Parks and Wildlife

November 06, 2022

Re: 1041 Northern Delivery Water System

# Triview Northern Delivery System (NDS) Project PMJM Critical Habitat Map

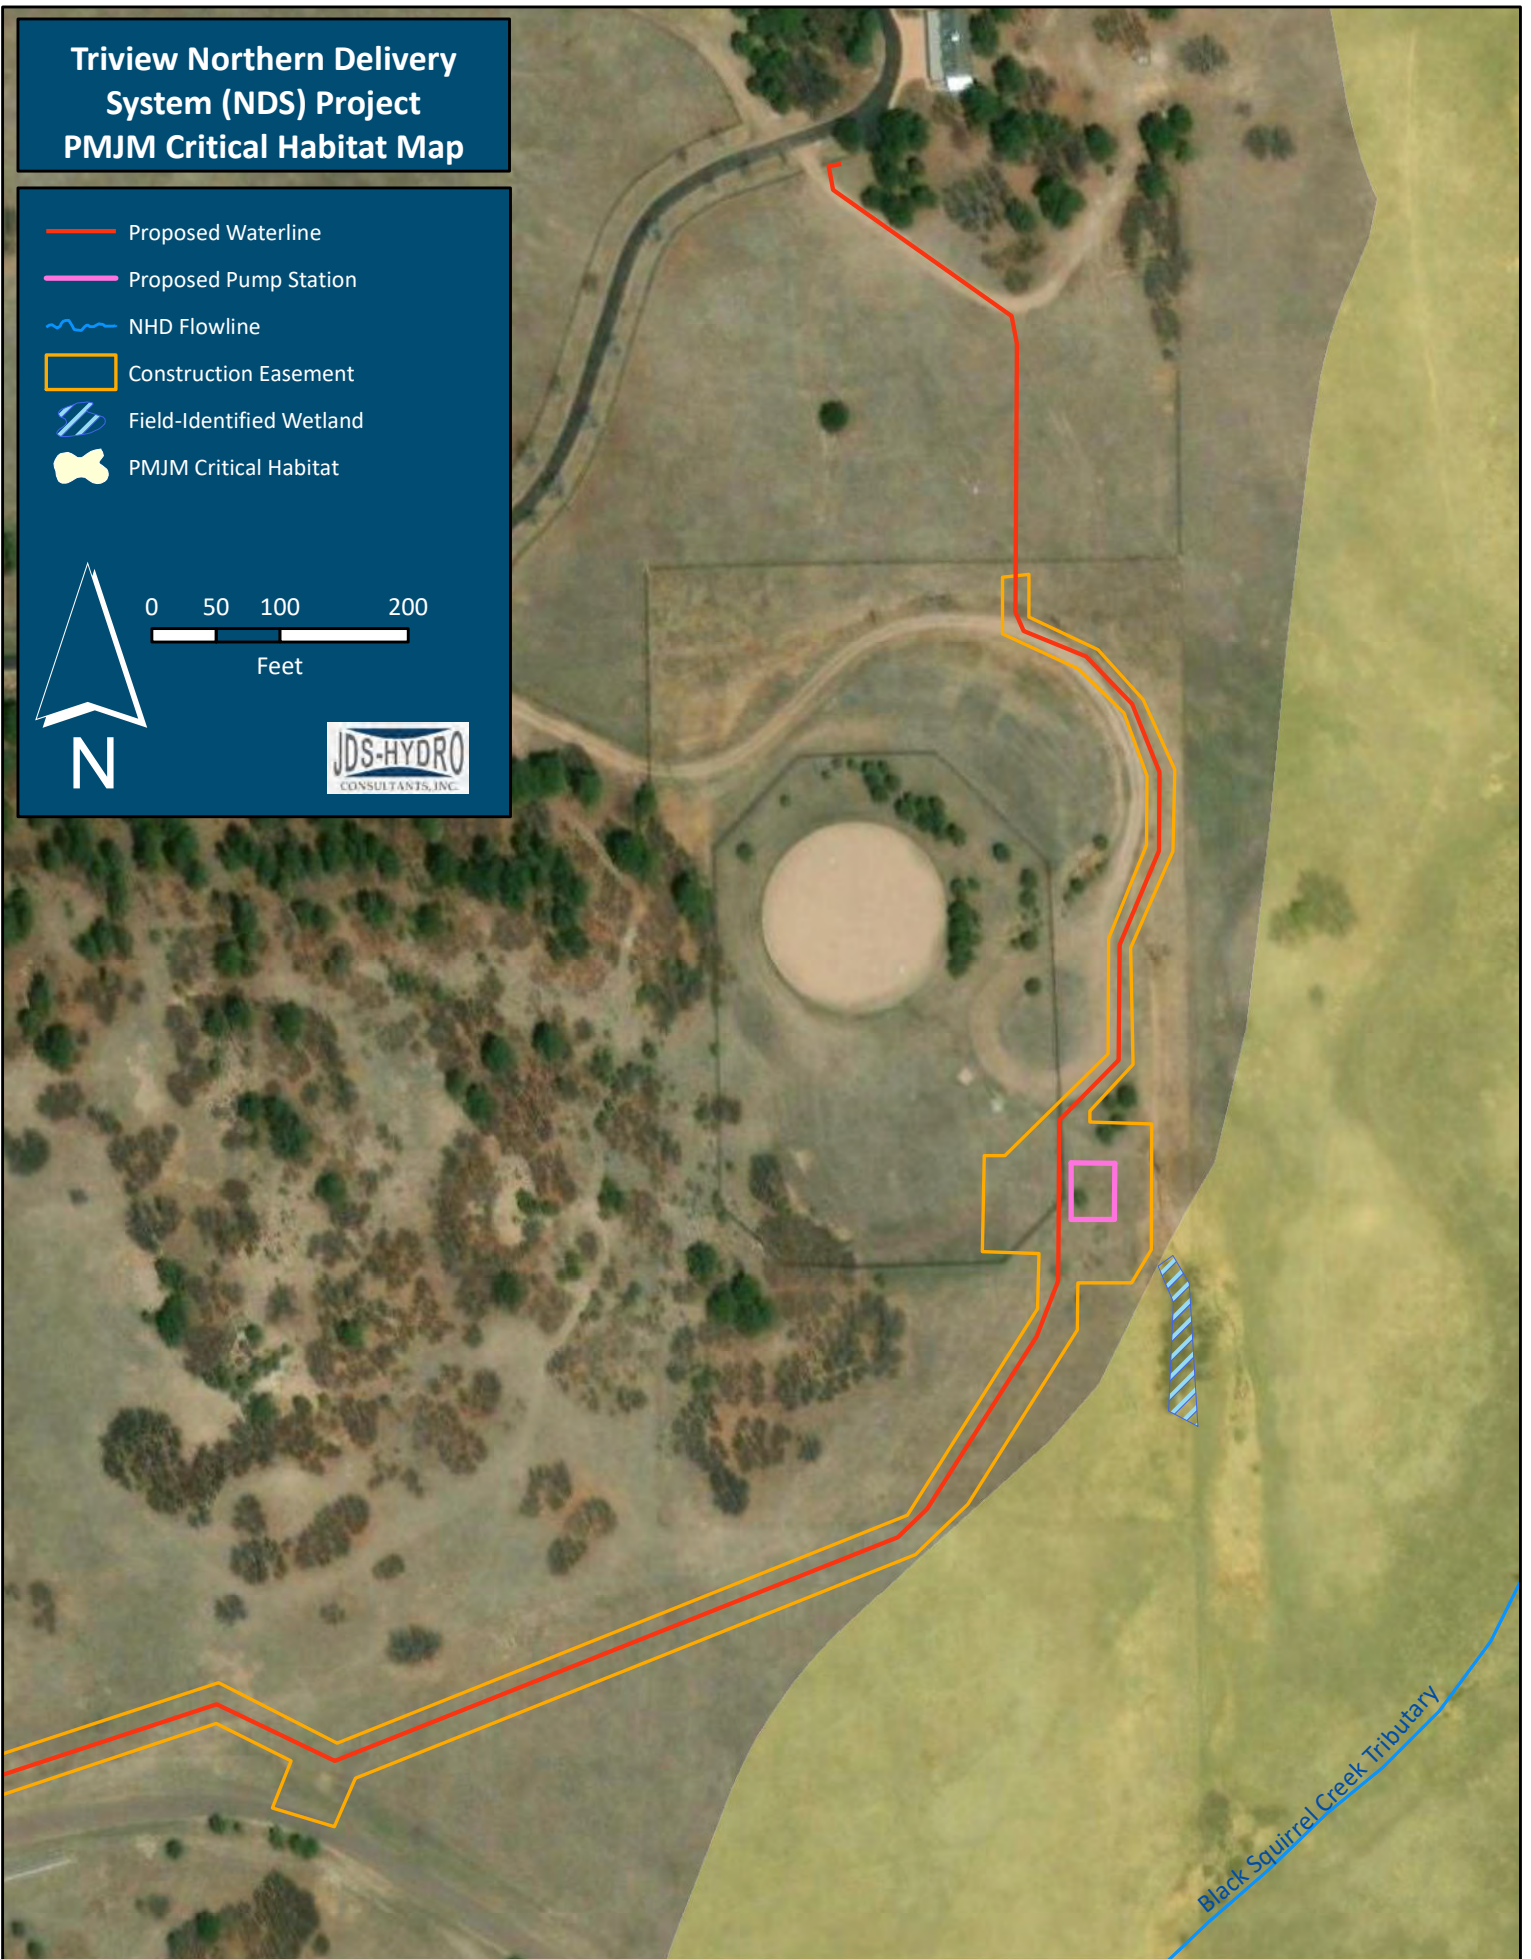
The southern terminus of the proposed waterline sits near or adjacent to Preble's Meadow Jumping Mouse (PMJM) critical habitat. PMJM is currently on both the Federal and State threatened species list. Temporary and permanent construction impacts in this area may temporarily or permanently impact resident wildlife. CPW recommends contacting the United States Fish and Wildlife Service for information regarding developing in or near potential PMJM habitat.
